Our Ref: TR010066

Date: 12 December 2024

### **Application by National Highways for an Order Granting Development Consent for the A46 Coventry Junctions (Walsgrave)**

#### **Advice following issue of decision to accept the application for examination**

Figure 8-3: Flood Zone 3 comparison

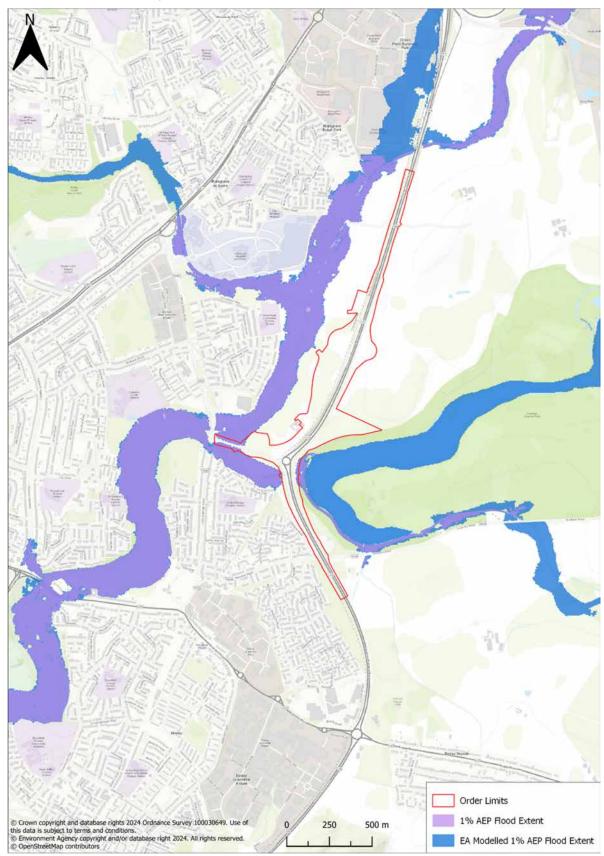
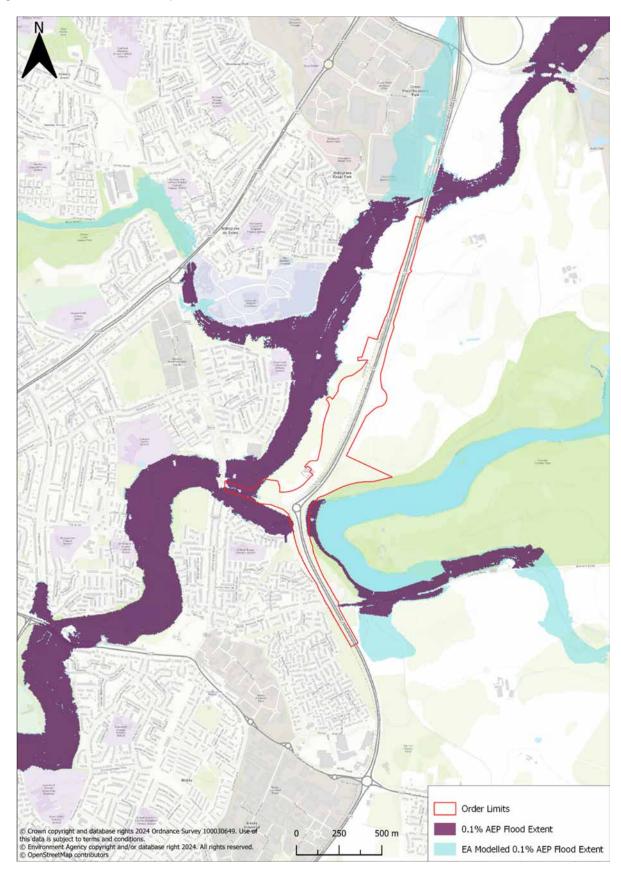
Whilst it is noted that the exception test appears to consider the requirements of Flood Zone 3b, the FRA does not provide specific information to differentiate between land within Flood Zones 3a and 3b. It is also unclear from the information presented whether the Proposed Development would result in no net loss of floodplain storage. The Applicant should respond to the Inspectorate as soon as practicable to confirm the location and extent of Flood Zones 3a and 3b and how this corresponds to the application of the exception test and the proposed flood mitigation/ compensation. If components would be located within Flood Zone 3b, the Applicant should provide confirmation that there would be no net loss of floodplain storage, in line with the principles of the exception test.
